RE: Resubmittal of ESC Plan SWQ-2025-00057 | Comment Response Letter

The following memo provides responses to SWQ staff comments for Target ABQ W Erosion Control and Sediment Plan located at St. Joseph's Dr NW between Coors Blvd NW and Atrisco Dr NW on November 21st, 2025. Staff comments are in *italic* followed by the Applicant responses that are in **red and bold**.

SHEET NUMBER  
**C302**

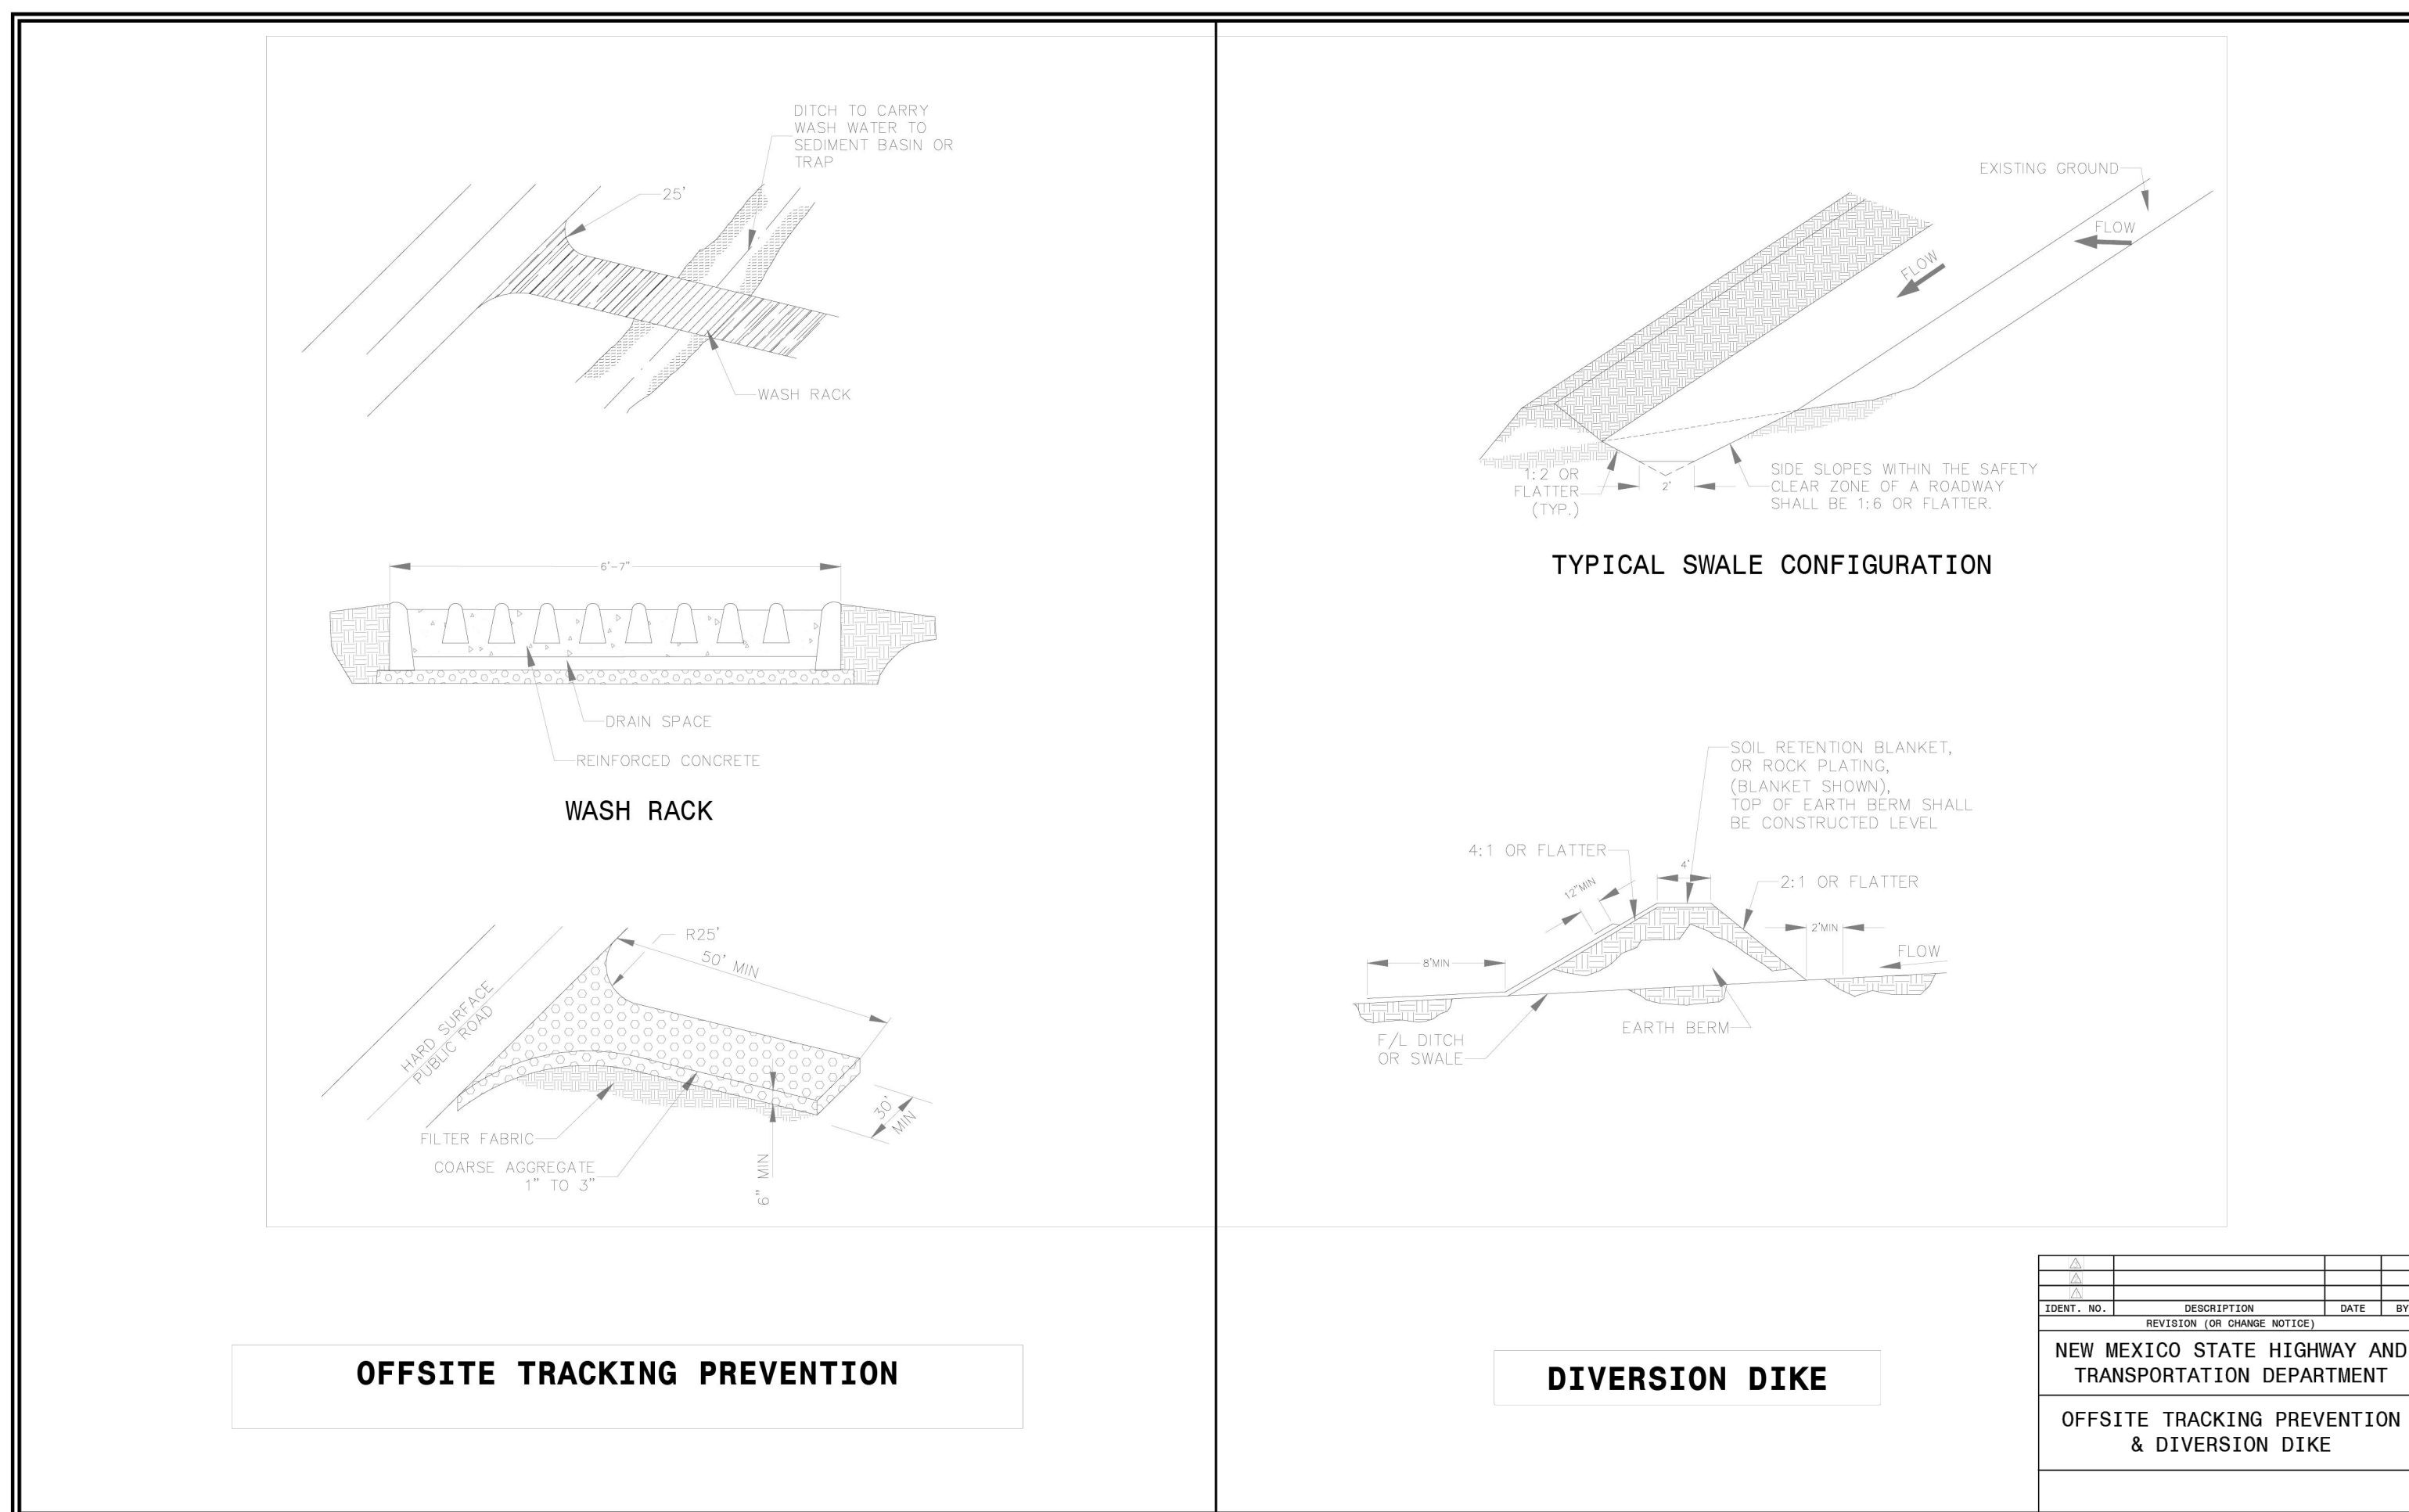
Include profile views with labels.

- A. the pond bottom elevation, area, and volume.*
- B. the sediment cleanout elevation, area, and volume*
- C. the elevation and area of the required volume*
- D. the overflow elevation, area, and volume*
- E. the 100-year elevation, area, and volume*
- F. the dam top elevation, area, and volume (if applicable)*

Applicant Response: Profile view with labels added to Sheet C302.

SHEET NUMBER
L102

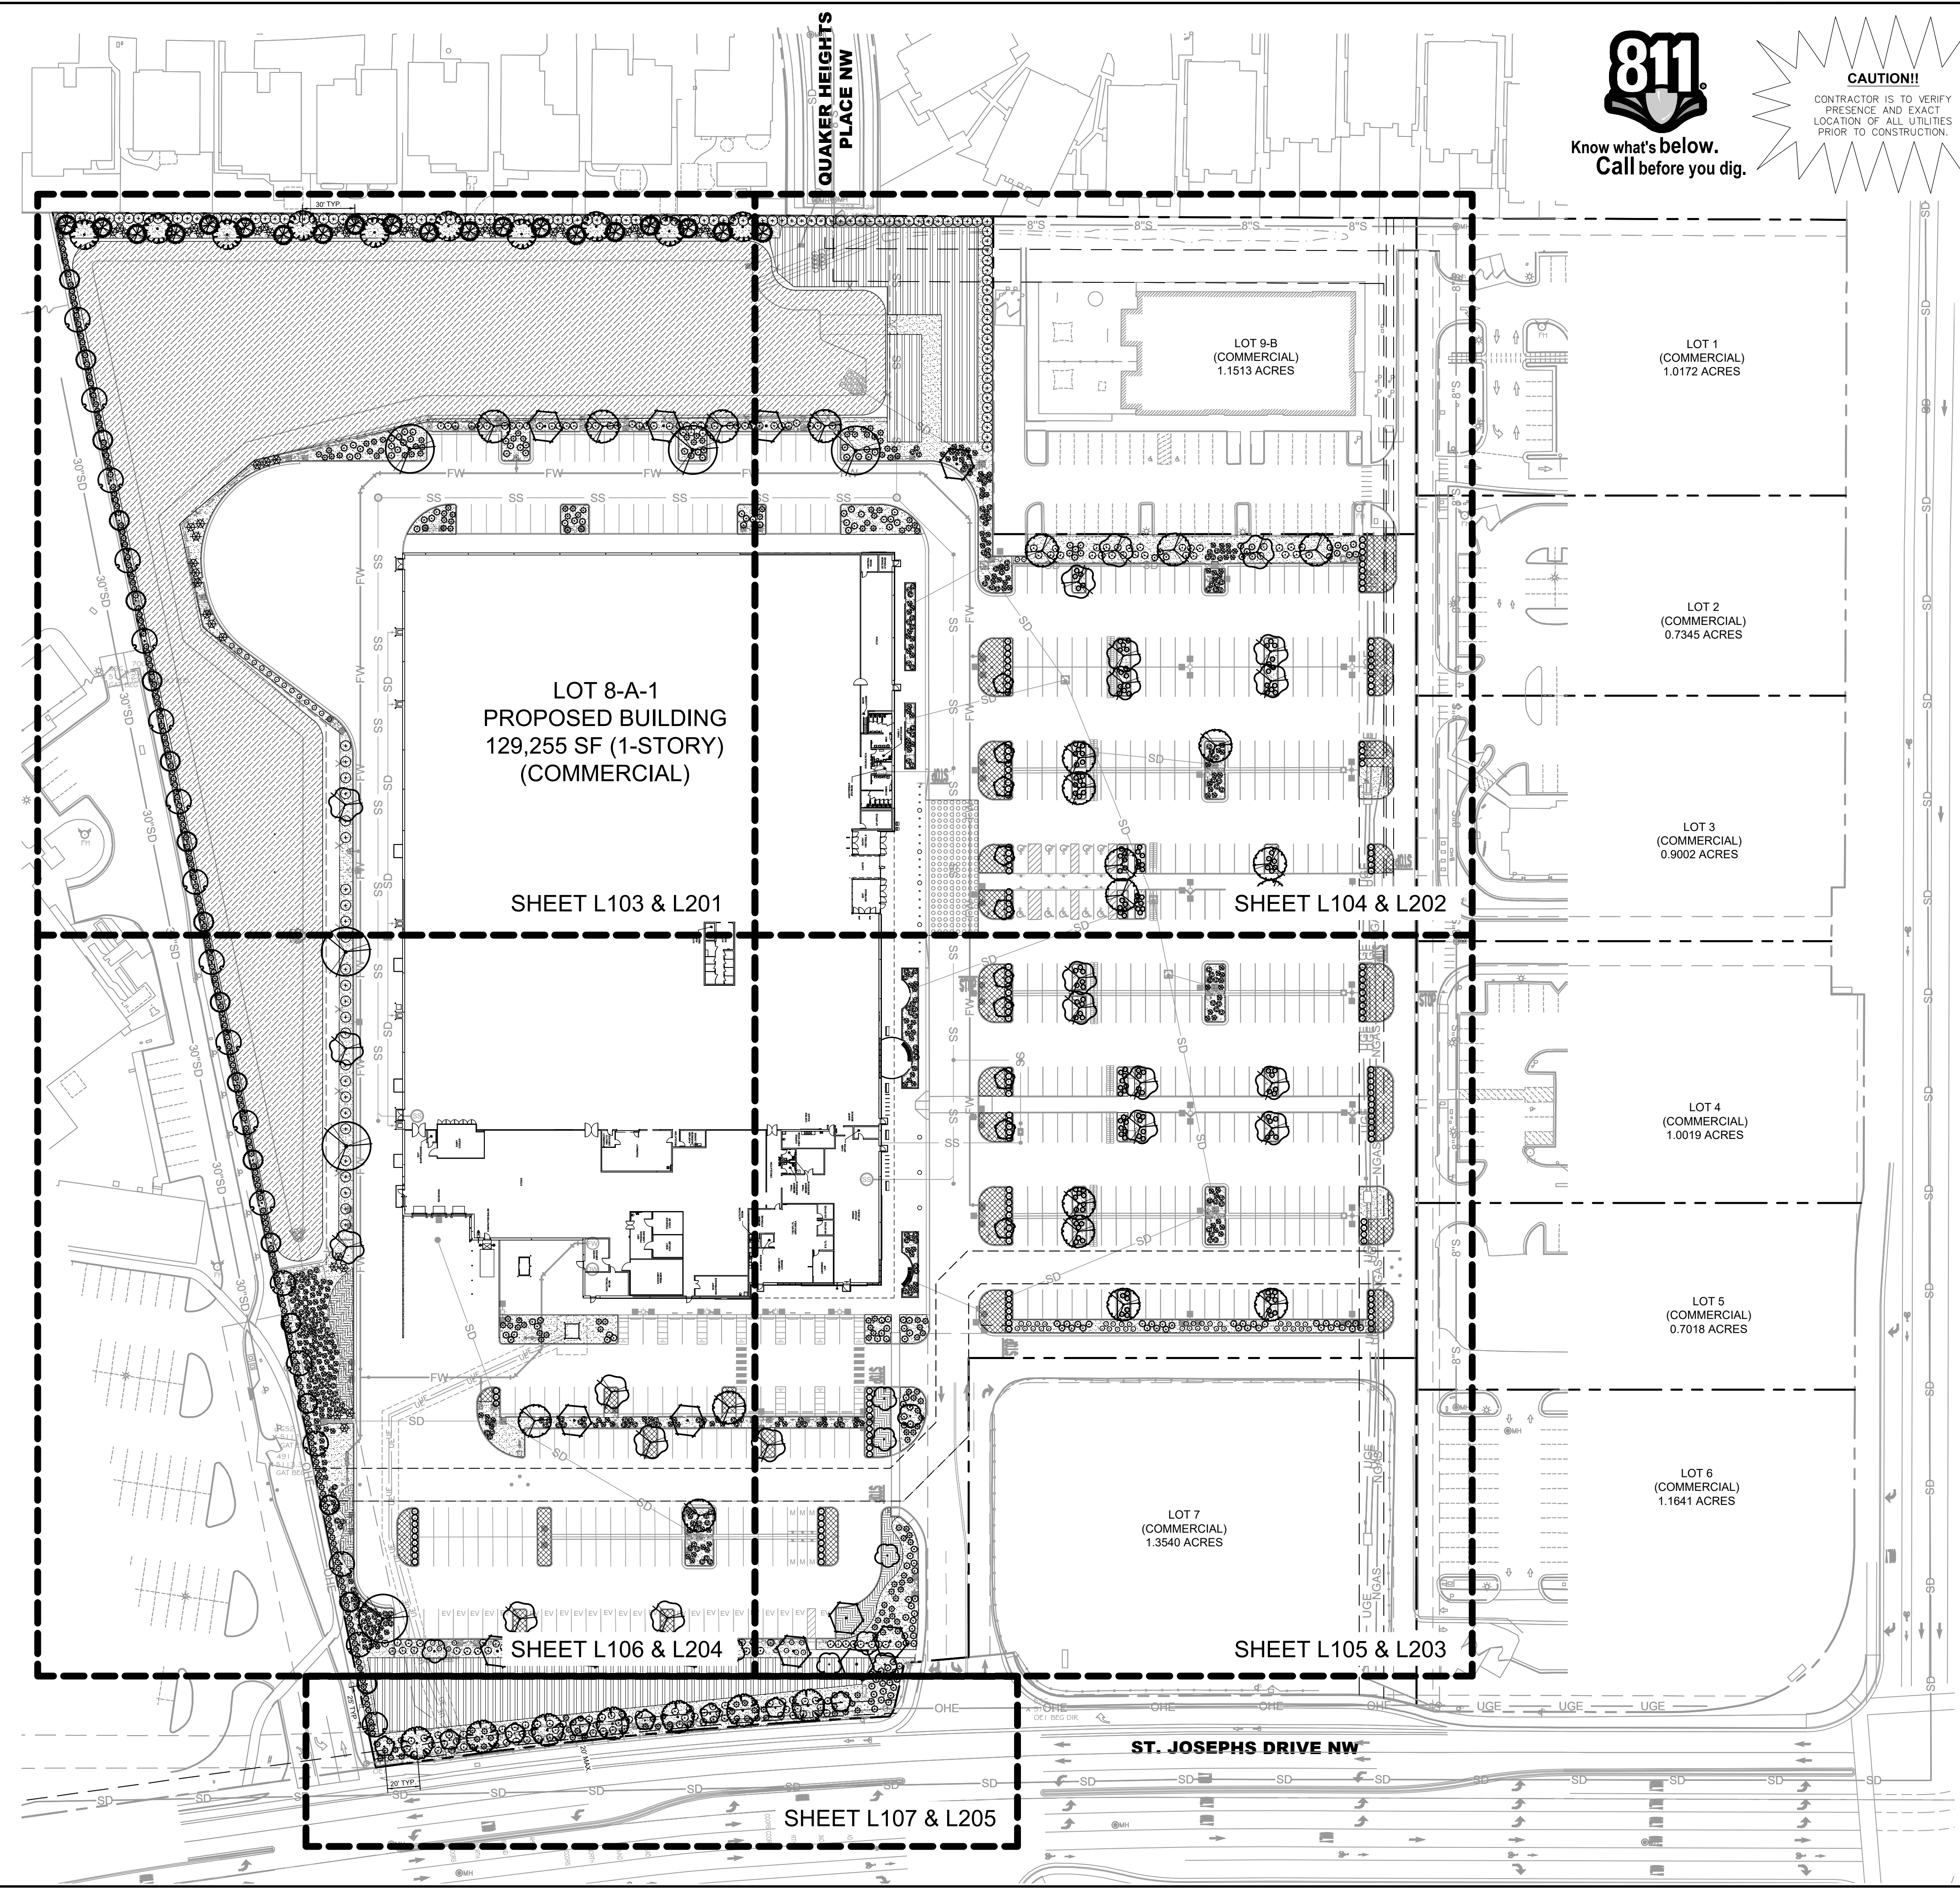
4. The SWPPP must include site-specific interim and permanent stabilization per CGP 9.6.1.c.i. The Landscape Plan can be used to satisfy this requirement and should be submitted separate from the ESC Plan with the application to the Stormwater Quality Section of the Planning Department, and it should be included in the SWPPP. Provide a specification on the ESC Plan for any disturbed areas not covered by the Landscape Plan and specify a "Landscape Buffer Swale" between the sidewalk and curb, per COA DWG 2414, along St Joseph's Dr.

Applicant Response: The landscape plan will be included separately as a part of this resubmittal.
